MONUMENT FIRE DISTRICT
16055 Old Forest Point, Suite #102
Monument, CO 80132
(719) 484-0911
www.monumentfire.org
Proudly serving the Tri-Lakes Region

July 15, 2024

Ref: Society of Classical Christian Education (SocCe) Site Dev plan

The Monument Fire District has completed the review of the 7/1/2024 Walker Road and the Society of Classical Christian Education Site Development plan. We have the following comments.

SITE PLAN KEYMAP

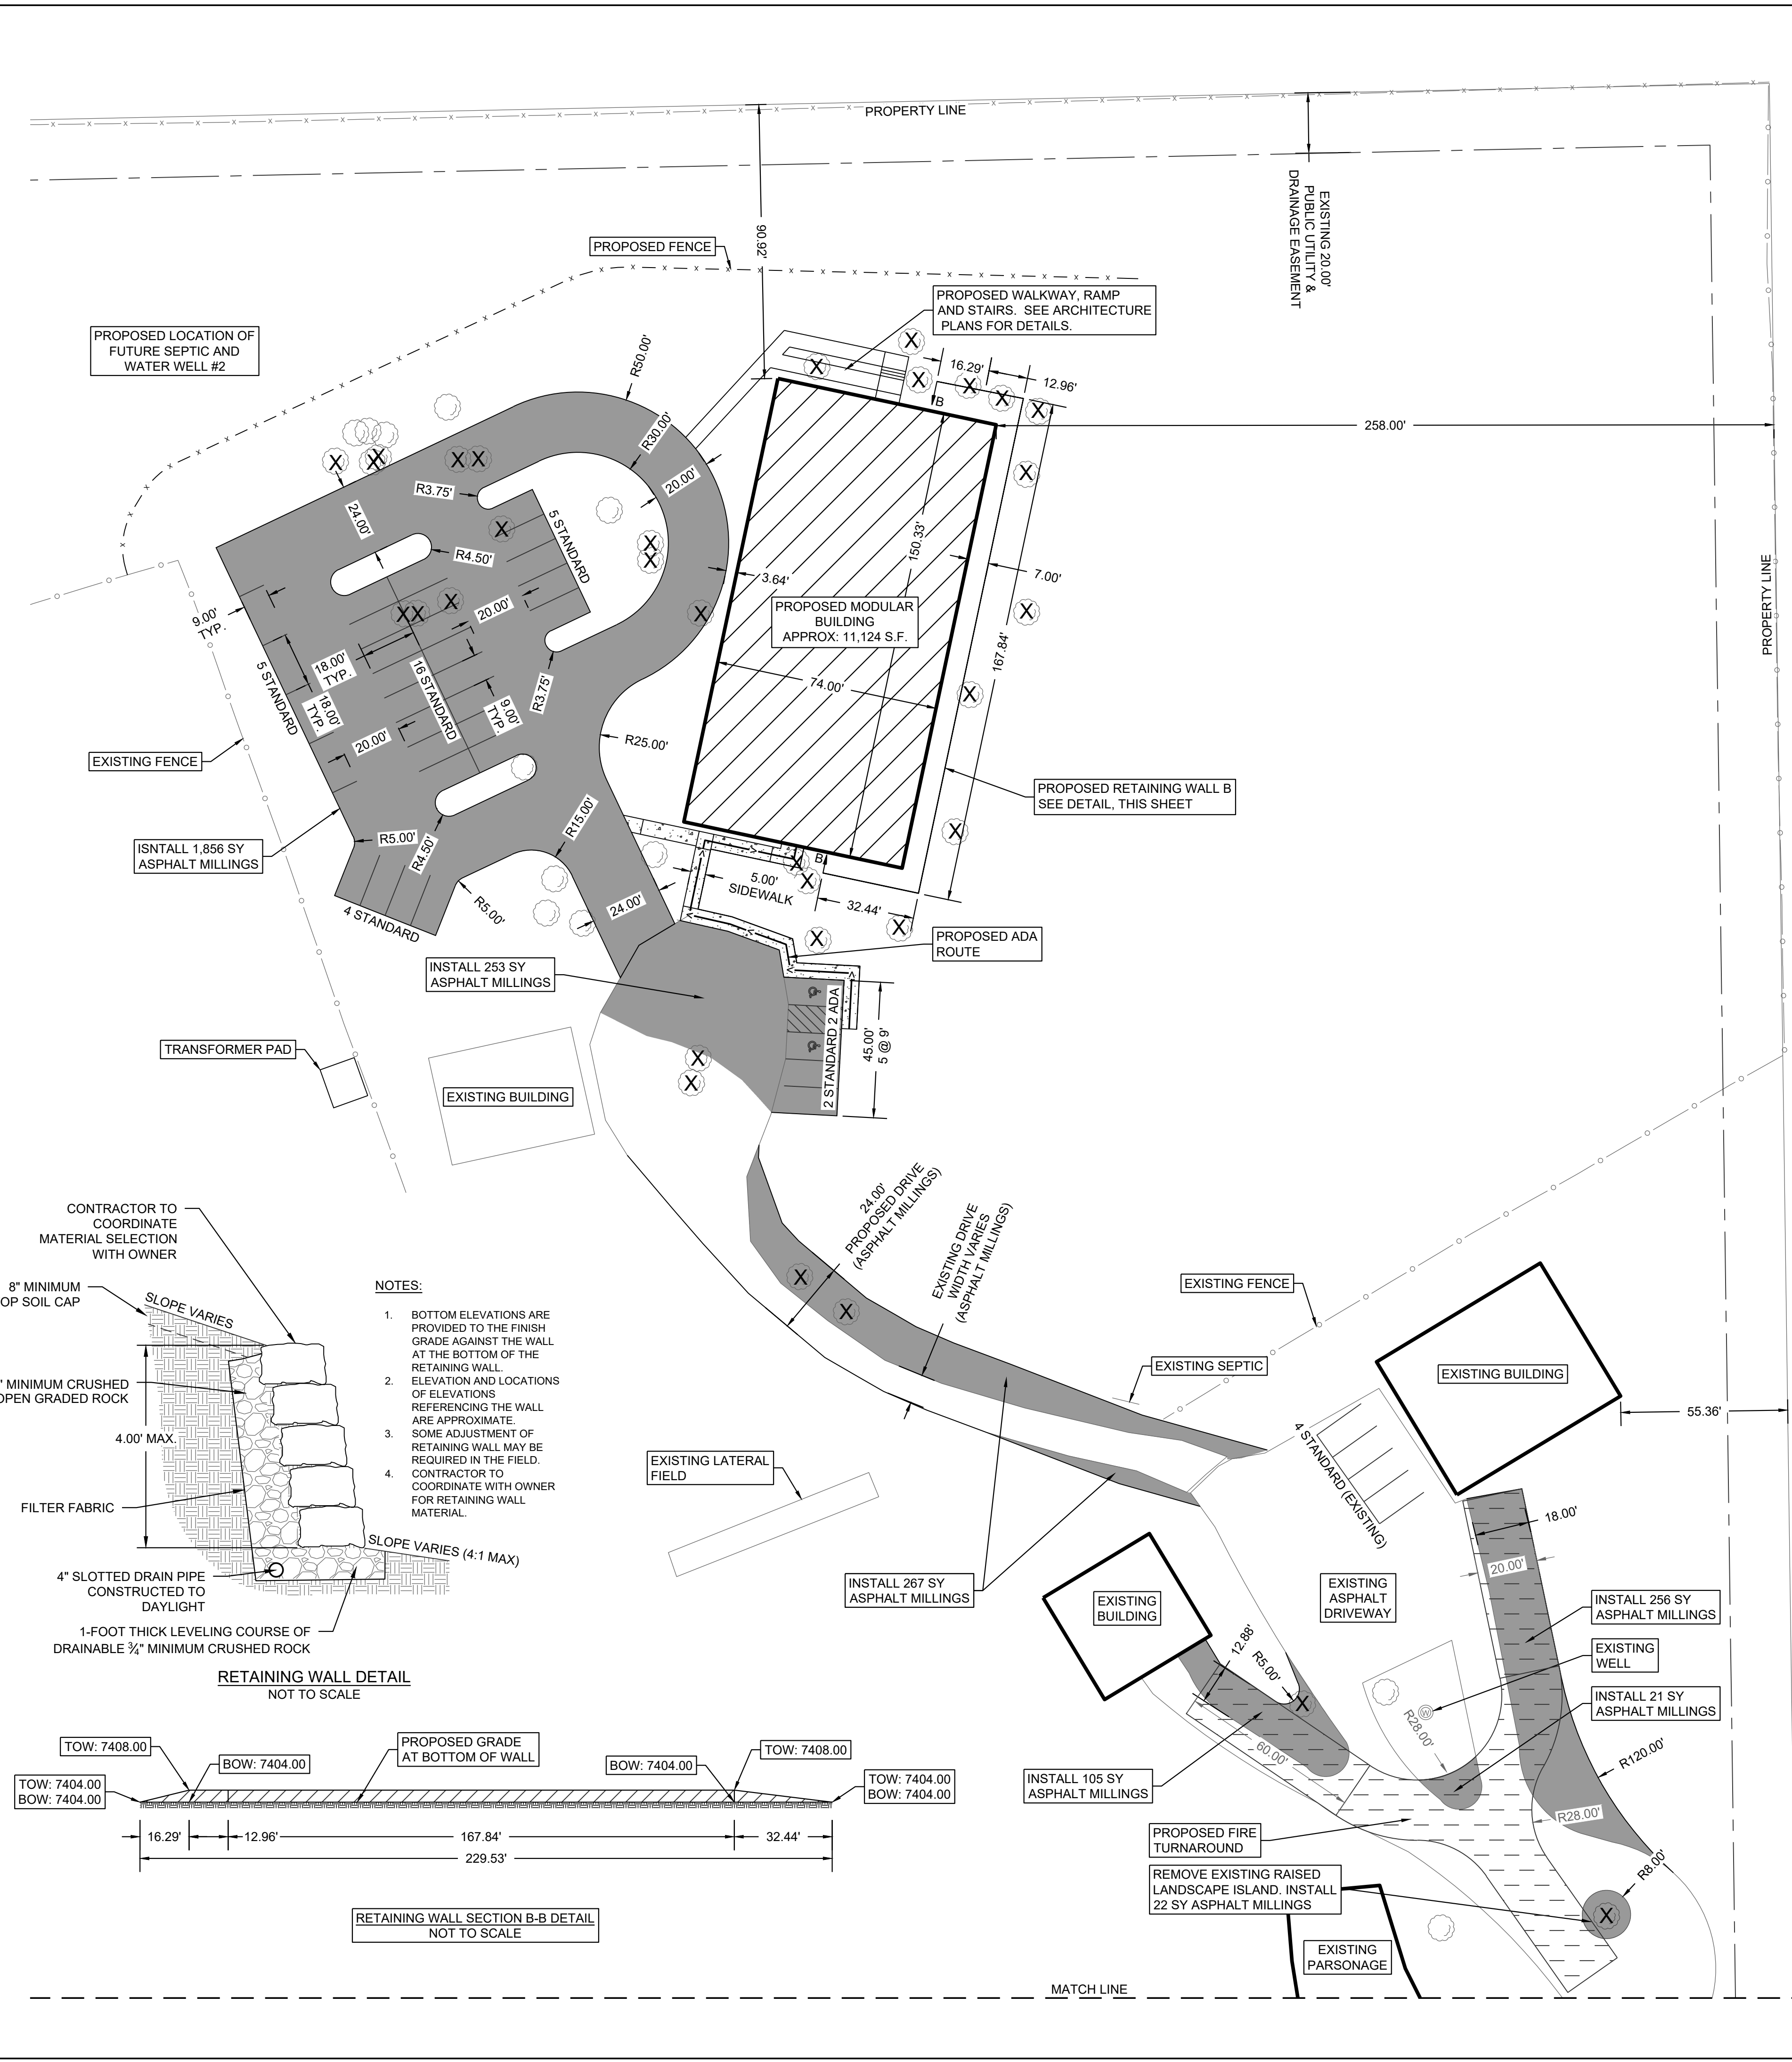
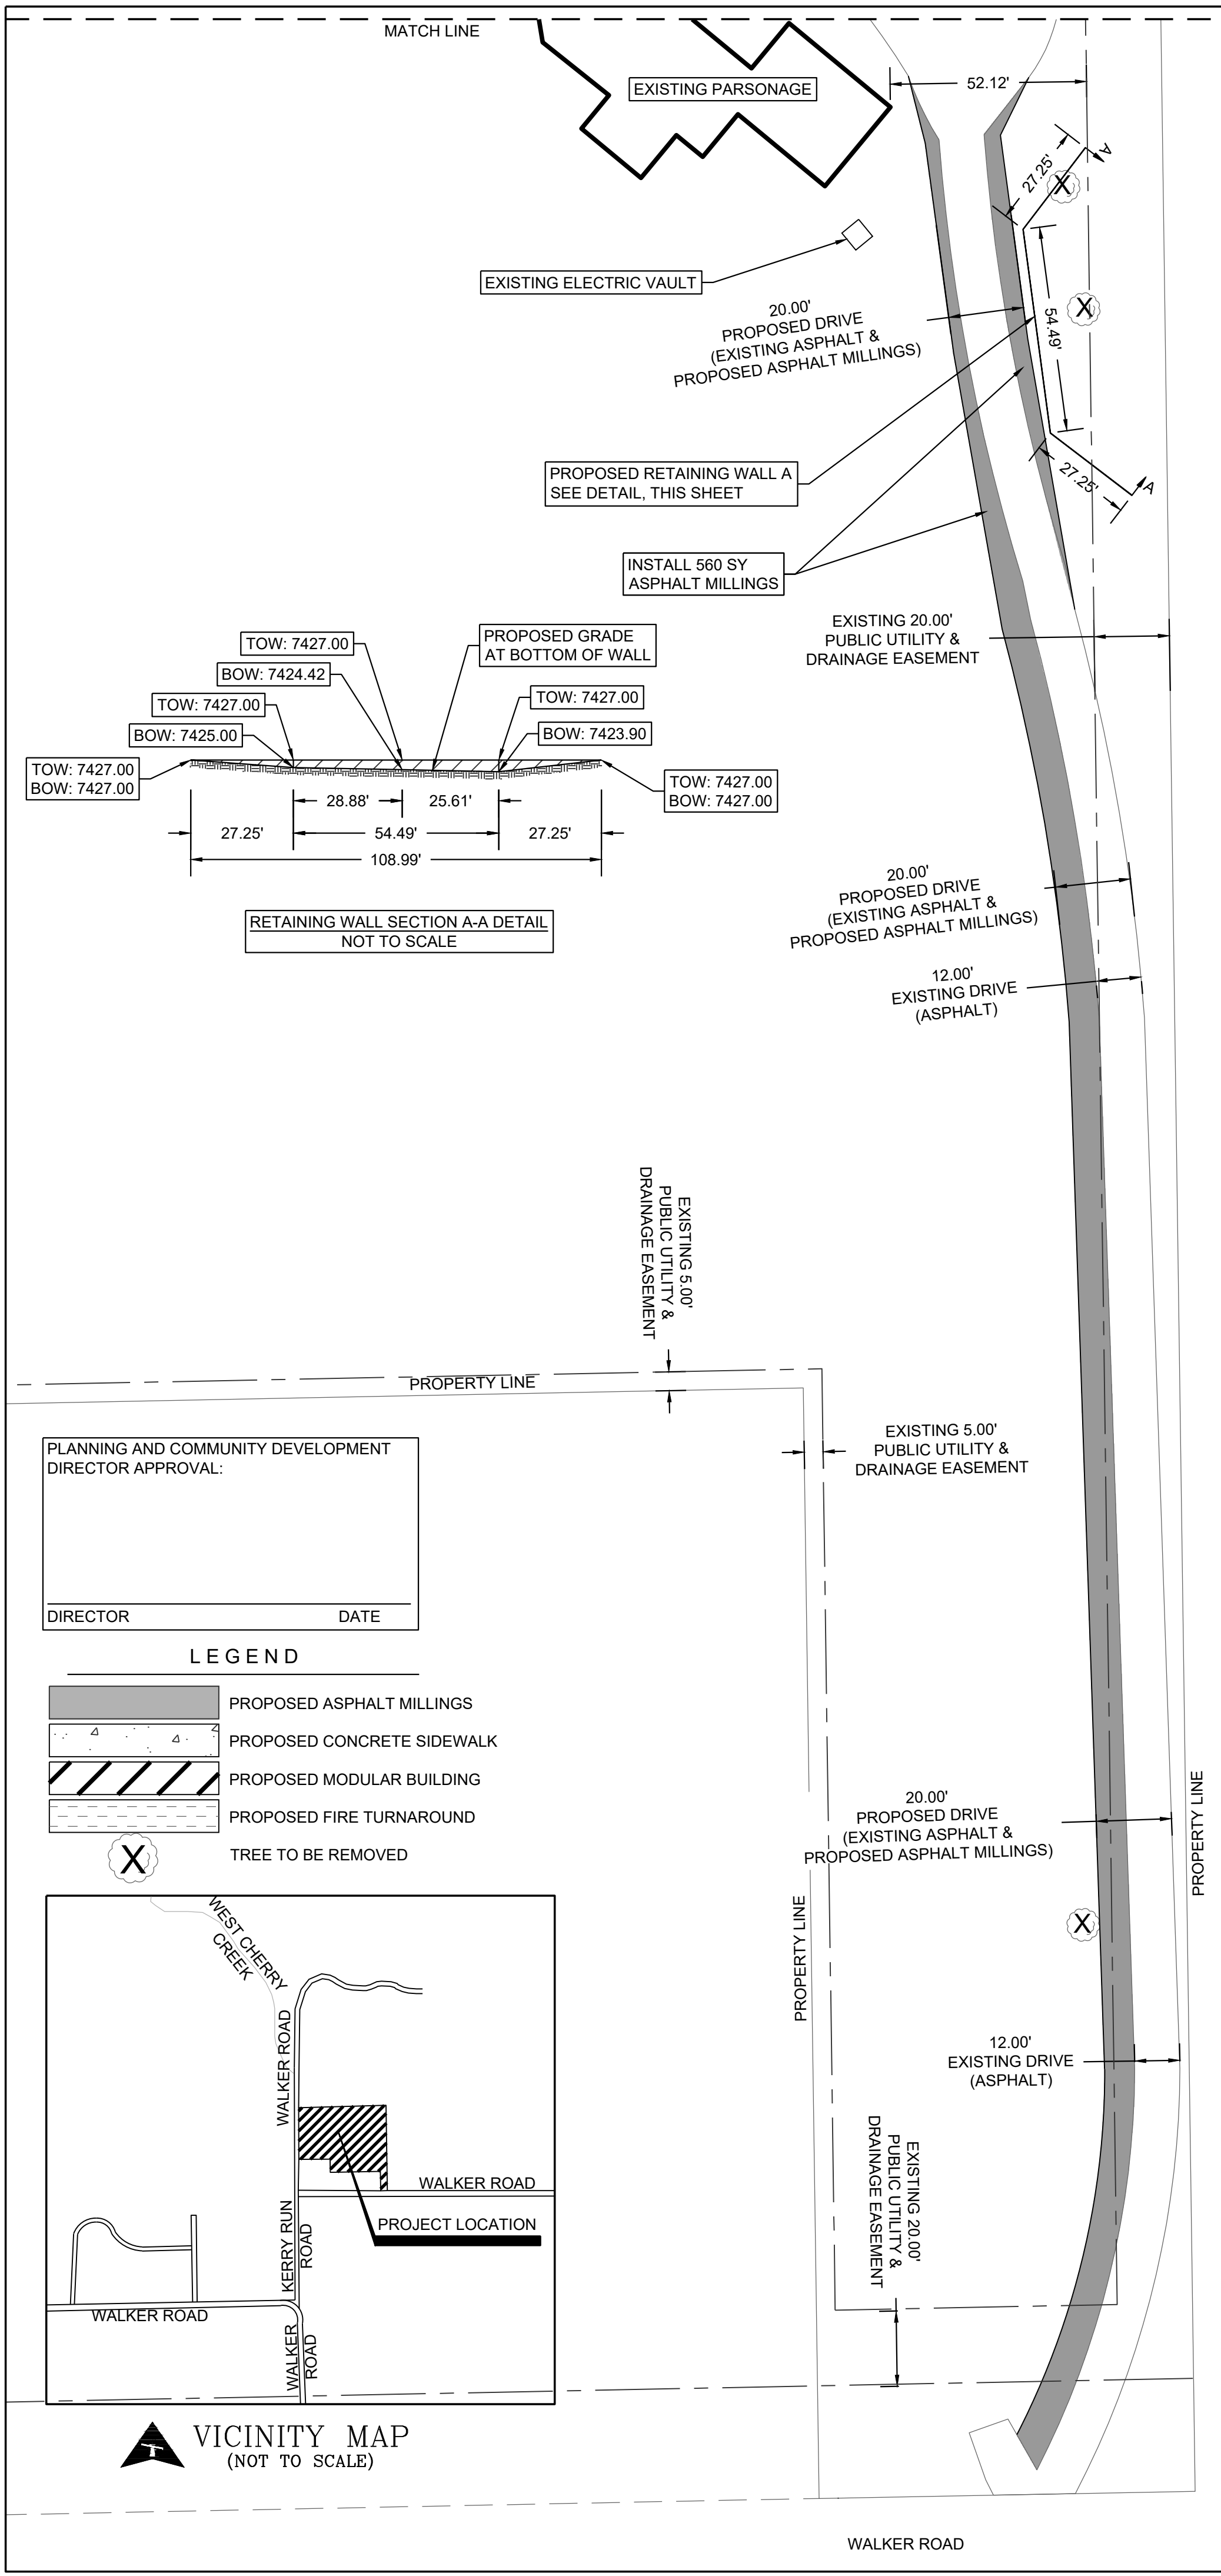
1. Fire Department Access:
 - a. The site development plan uploaded to the EDARP system on 7/1/2024 meets the fire department access requirements from Walker Rd to the building site outlined in our letter dated 3/14/24.
2. Firefighting Water Supply:
 - a. In our letter dated 2/21/24, the fire department requested the applicant address firefighting water supply. We do not have all dimensions of the building, however, see below for required water supply based off several different building heights.
 - i. 11,124 SqFt/9Ft building height = 25,029 firefighting water supply
 - ii. 11,124 SqFt/10Ft building height = 27,810 firefighting water supply
 - iii. 11,124 SqFt/11Ft building height = 30,591 firefighting water supply
 - iv. 11,124 SqFt/12Ft building height = 33,372 firefighting water supply
